Dangerous Goods Review

Western Sydney University
Bankstown City Campus
Development

Date: 28th May 2019

Project No.: 6517

DRAWING No.
DA30-01

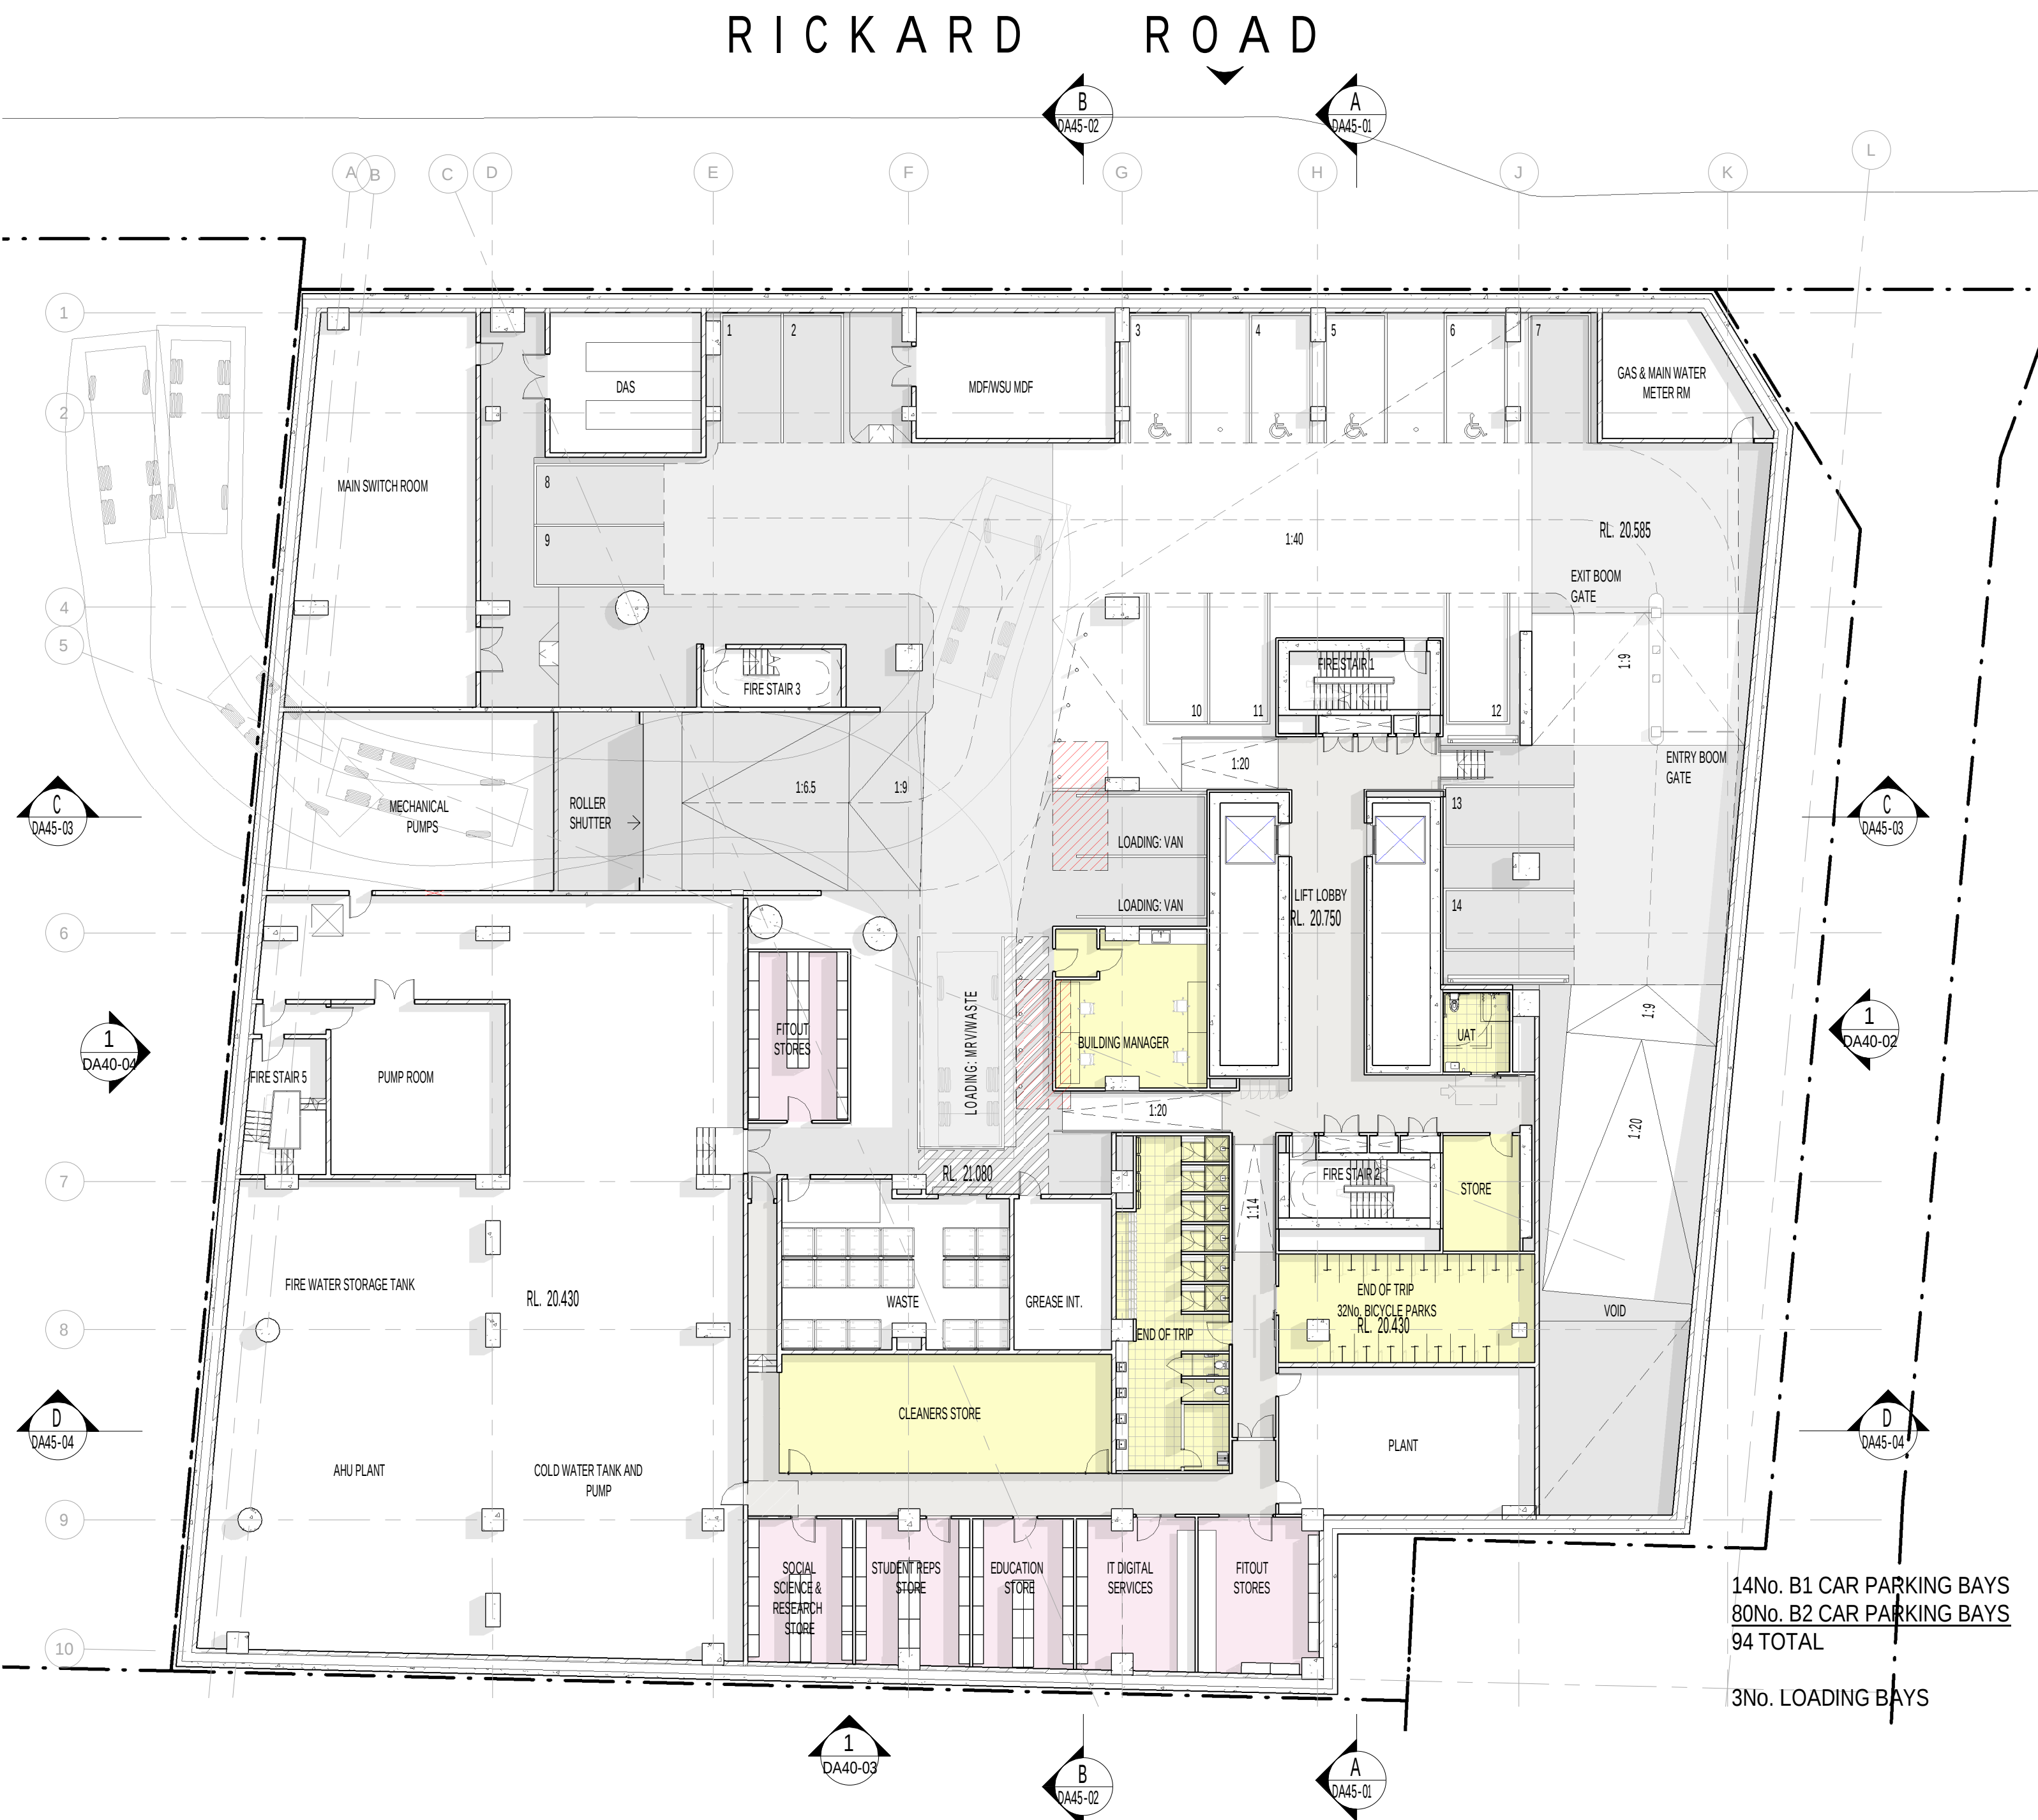
The underground diesel tanks in Basement Level 2 are well separated from incompatible activities. The type of tanks, the design for the underground storage and the fill points are to be finalised.

Provide a means to contain spills so they cannot escape into the environment. An inground tank should be double walled. A tank in a chamber should have liquid tight floor and walls to bund wall height.

ACTION:	If the tanks are direct in-ground, the structural engineer should provide written approval that loads from the building foundations and supports are not transmitted to the tanks and that the tanks are securely anchored.	Open
----------------	---	-------------

ACTION: Advise whether the tanks will be installed in an underground chamber. If installed in a chamber, provide the design and fill specifications. Open

ACTION: Advise the method used for corrosion protection of the tank. Open

DA30-21 **1**

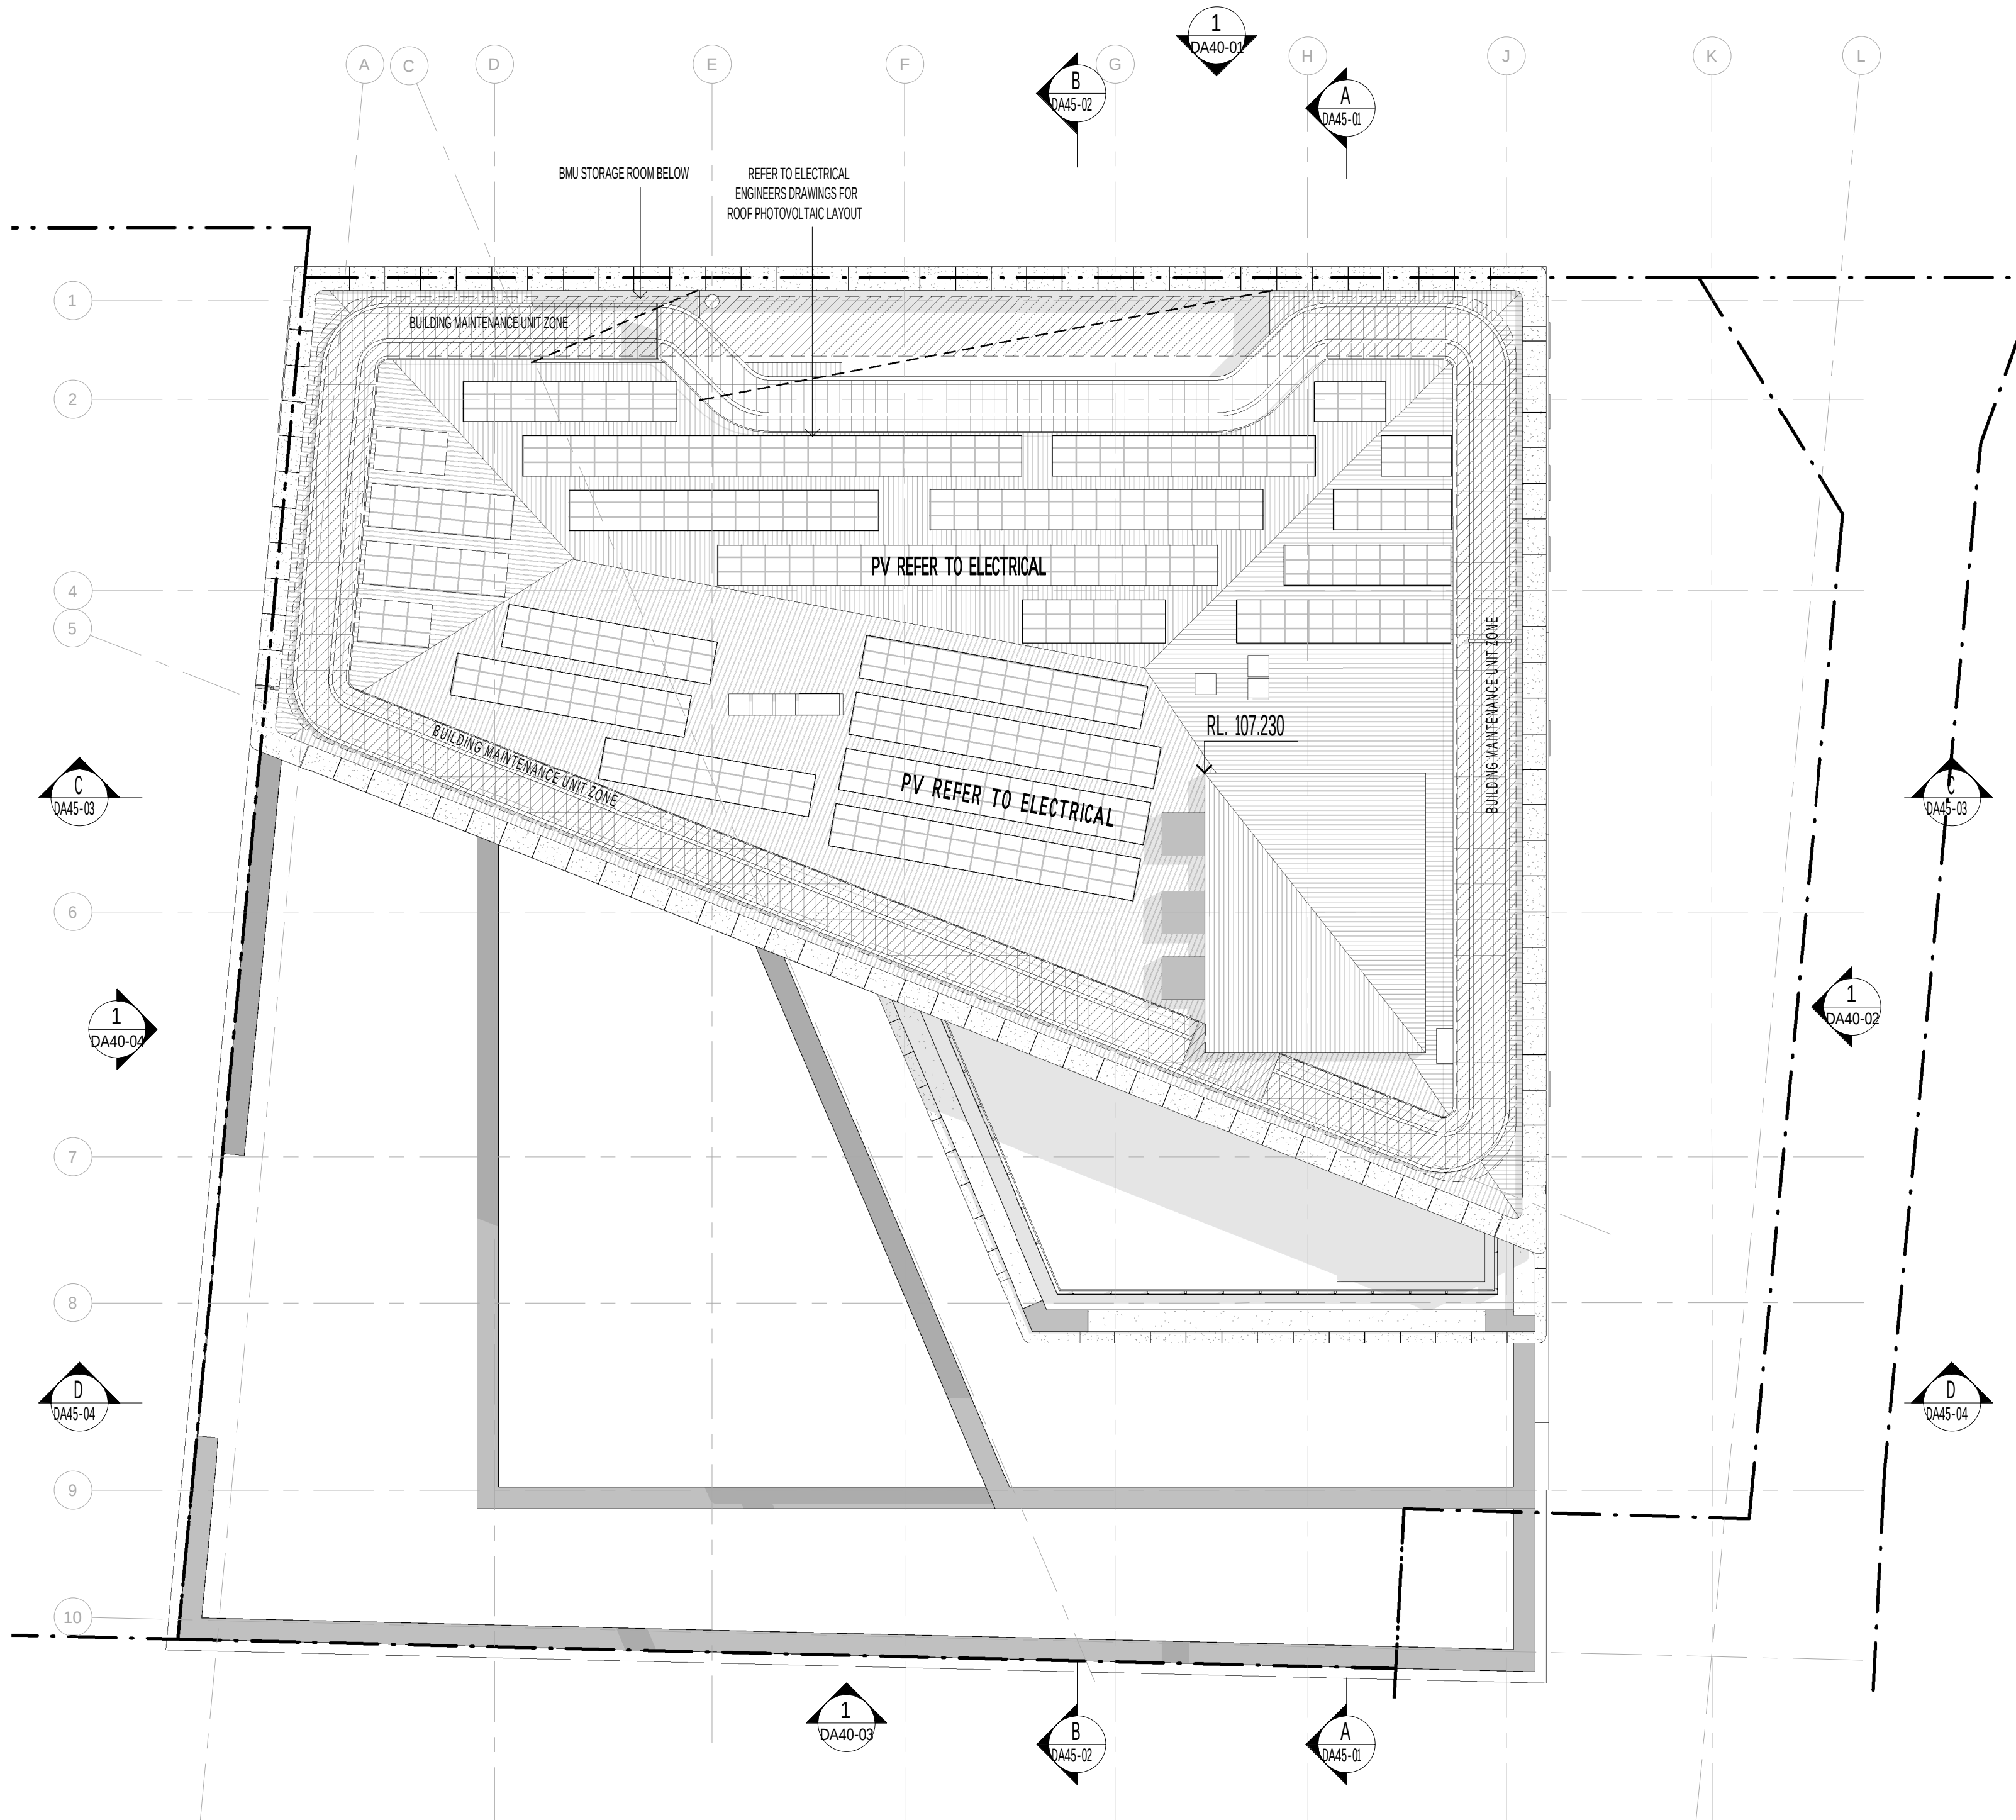
The new diesel generators on level 18 are well separated from incompatible activities but the ventilation of the area and the method for spill containment of the fuel.

ACTION: Advise the extent of natural ventilation around the diesel day tanks. **Open**

ACTION: Provide the specification for the generator showing the day tank and the method of spill containment. **Open**
